Town of Addison

Summary of Engineering Review Comments

Date: August 23, 2019
 Plan Review : Civil Review 1
 Received: July 30, 2019
 Plan Date: July 25, 2019
 Development: Galaxy FBO

Town Project #:19-09D

SHEET NUMBER
C09.01

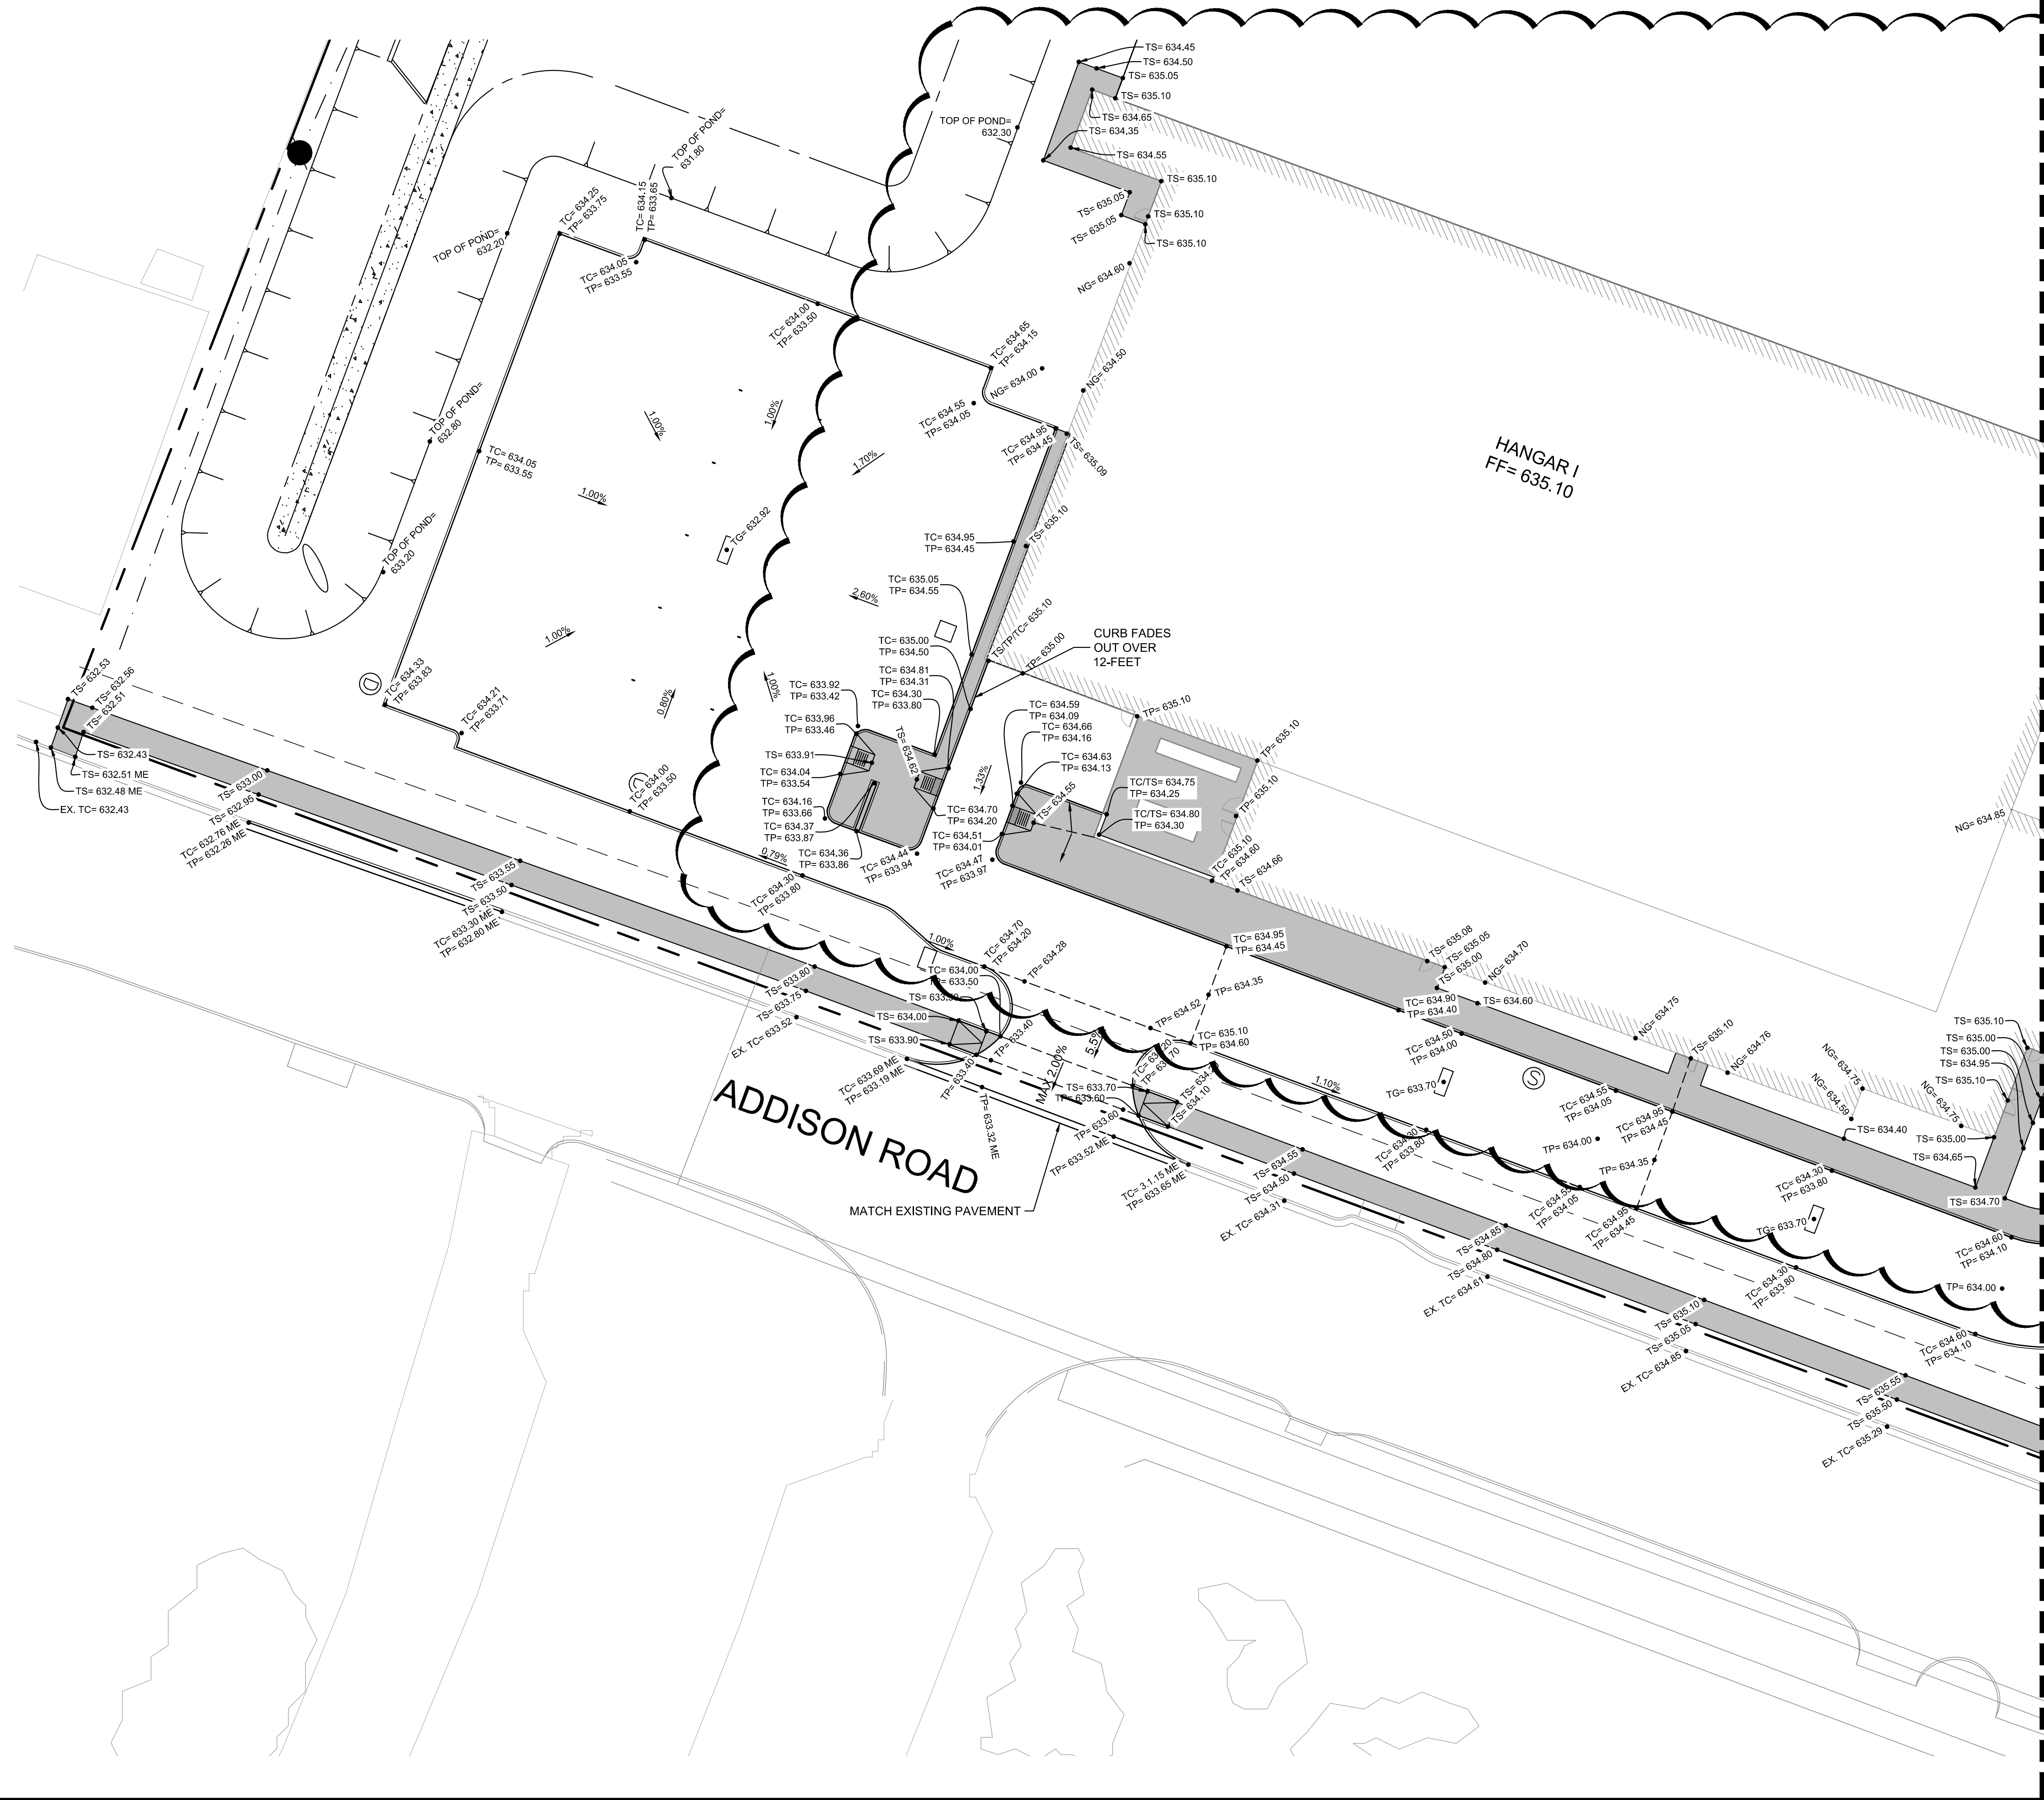
Page No.	Comments	Response (See Note)	Explanation
C09.01	Provide grades for curb replacement	AGREE	
C09.01	BFR's should have return curbs, not wings.	AGREE	
C09.01	Add TOC & back of sidewalk grades w/ max 2% grade callouts for parkway.	AGREE	
C09.02	If the darker crosshatched area is pedestrian, need spot grades.	DISAGREE	THIS AREA IS FOR LANDSCAPE
C10.00	Need pre-development & post-development DAM's.	AGREE	AN EXISTING DAM SHEET HAS BEEN ADDED, SEE SHEET C11.00
C10.00 & 12.07	Seems that at least some of the fuel farm drainage is captured by or flows through your site. Coordinate with Dave Wilde for records & show how this is being handled.	AGREE	THE FUEL FARM DRAINAGE HAS BEEN INCORPORATED INTO THE SYSTEM
C10.00	Legend shows DA boundaries are existing, but they match the proposed layout.	AGREE	
C10.01	City of Houston drainage manual???	AGREE	ALL STORM CALCULATIONS ARE PERFORMED PER TOWN OF ADDISON DRAINAGE CRITERIA MANUAL, SEE UPDATED NOTE

SHEET NUMBER
C17.02

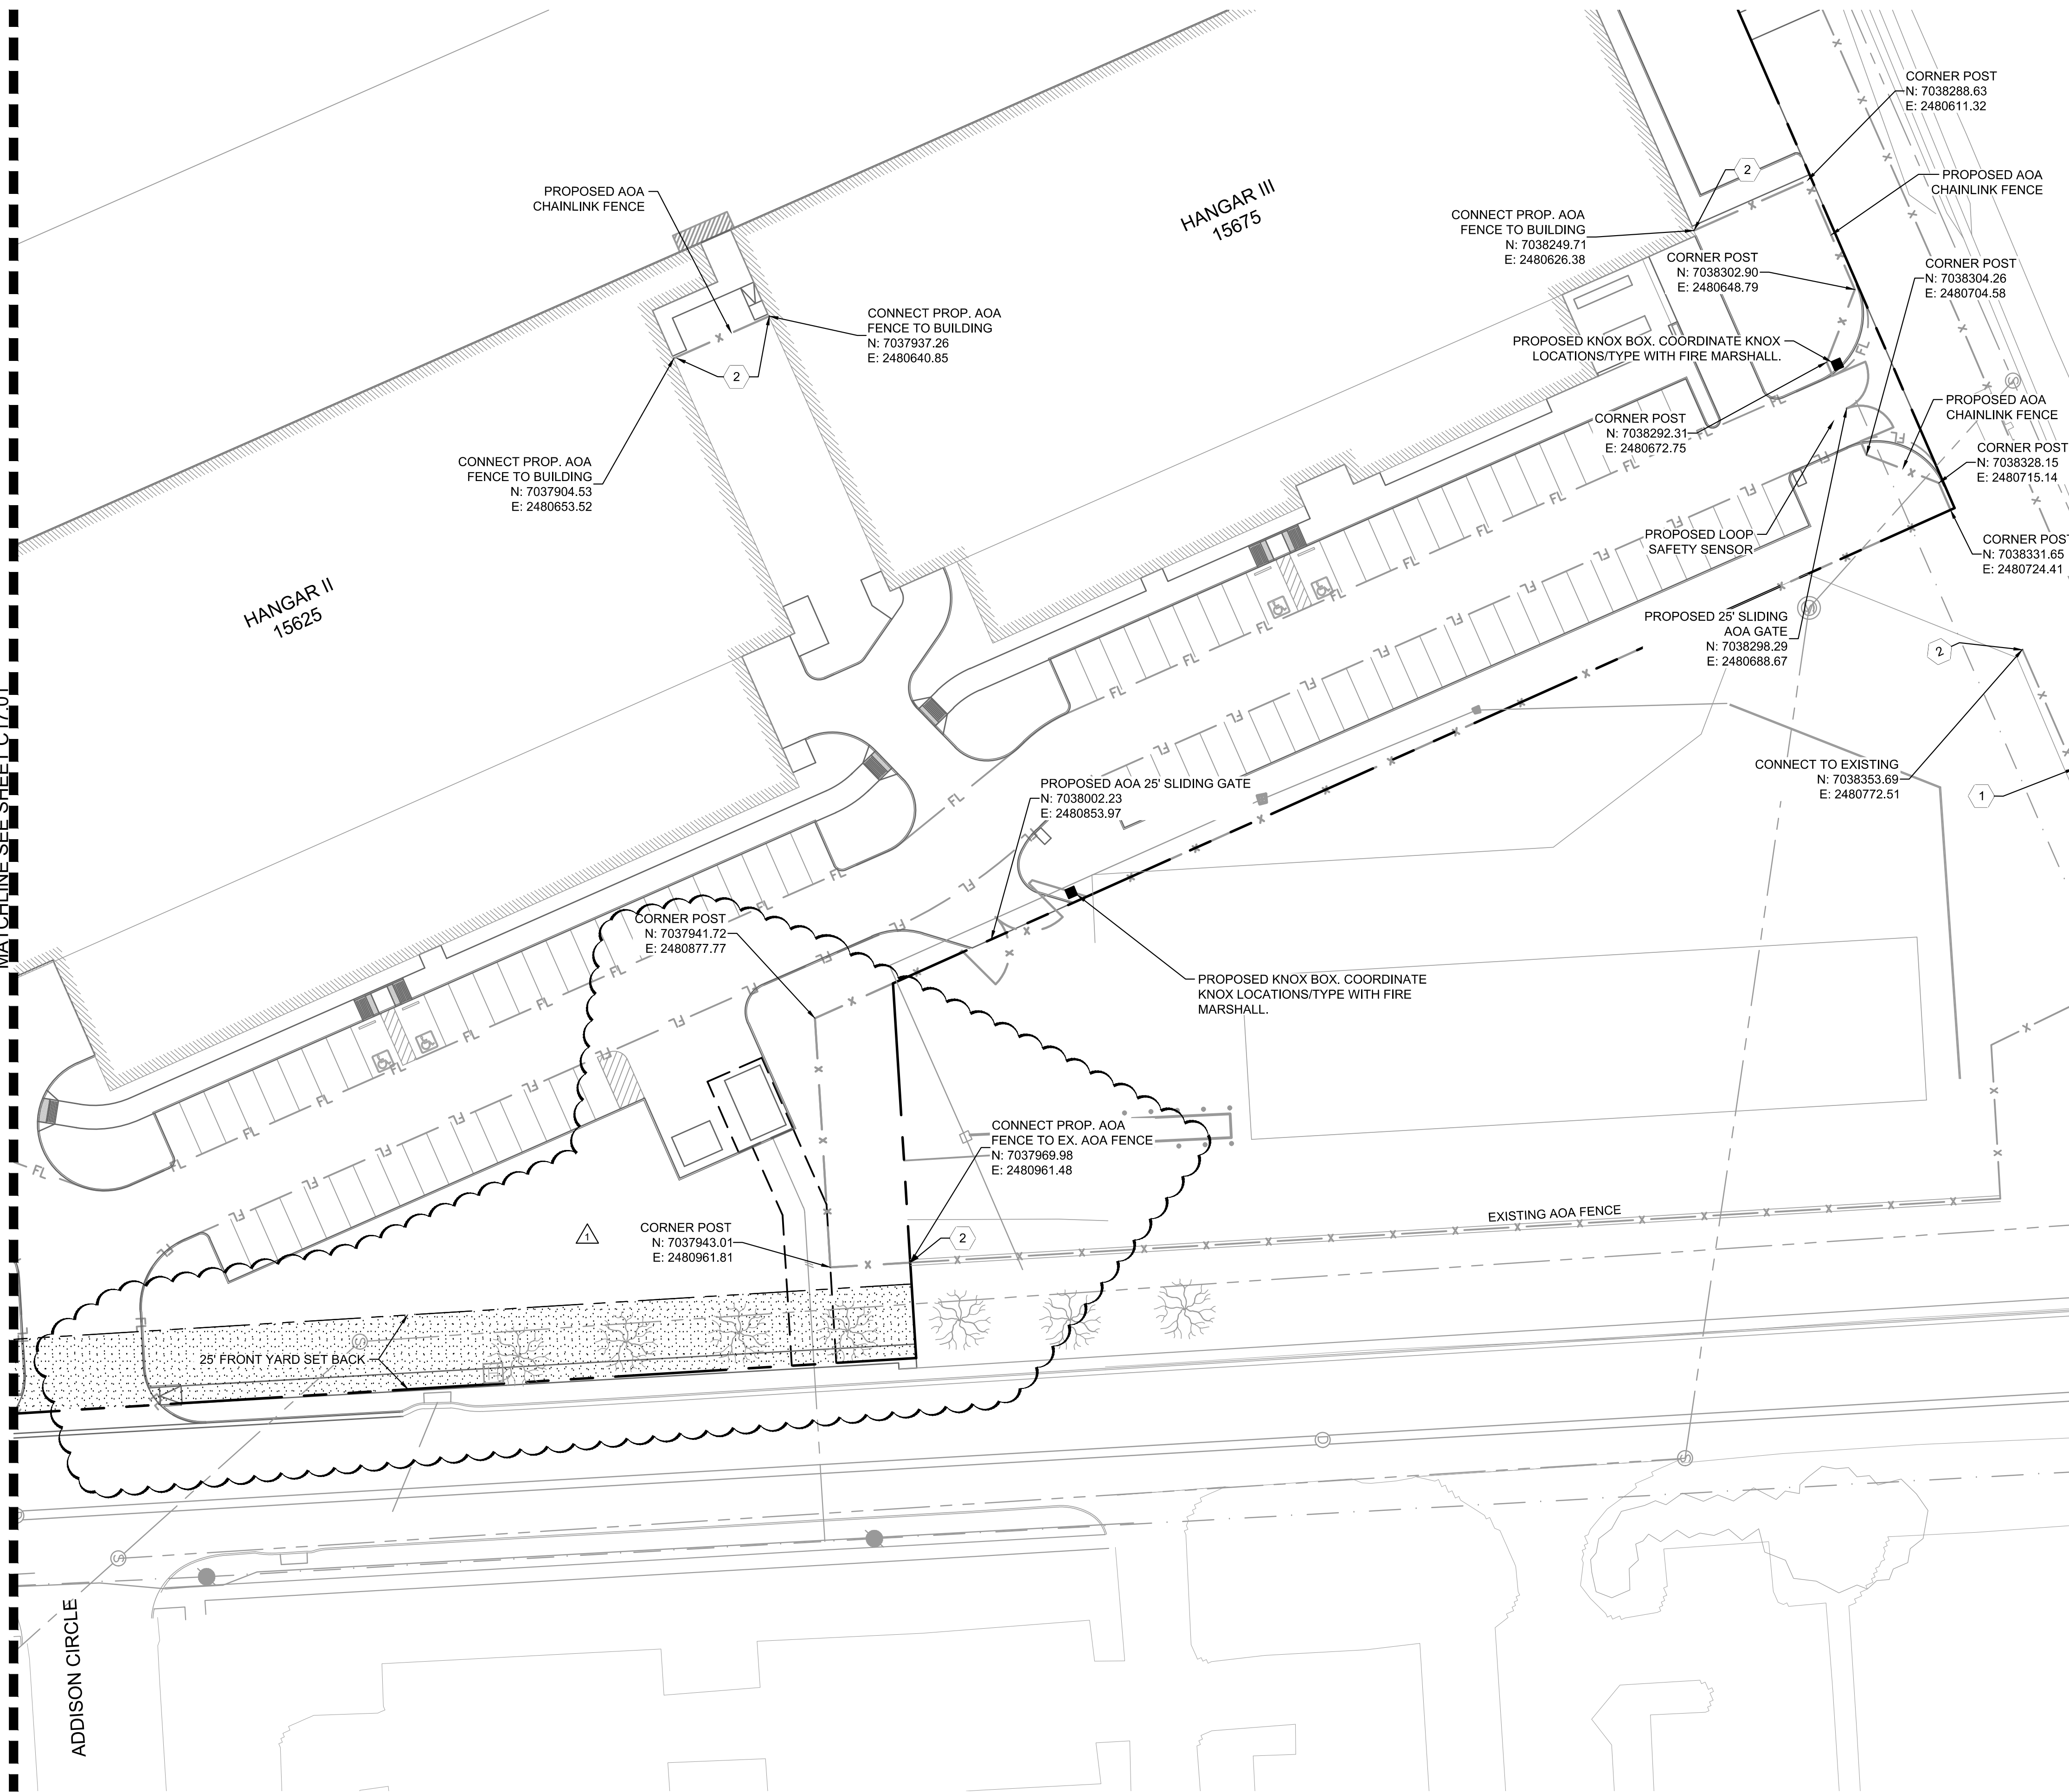
C17.02	Will the proposed AOA gate to the fuel farm be swing or slide?	AGREE	GATE IS TO SLIDE, SEE UPDATED LABEL
C17.04	Detail for swing gate?	AGREE	SEE SHEET C17.03
LANDSCAPE	Many proposed trees are too close to utility lines/appurtenances. Tree trunks should be a minimum of 8' from outside edge of utilities.	AGREE	
LANDSCAPE	Show concrete pads for FHA's/Valves/MH's/vaults, etc.	AGREE	
LP1.01	Include transportation visibility triangles (Fig 3.6), not just the landscape triangles.	AGREE	SEE ATTACHED SIGHT VISIBILITY TRIANGLE EXHIBIT
LP1.01	No seeding. Sod.	AGREE
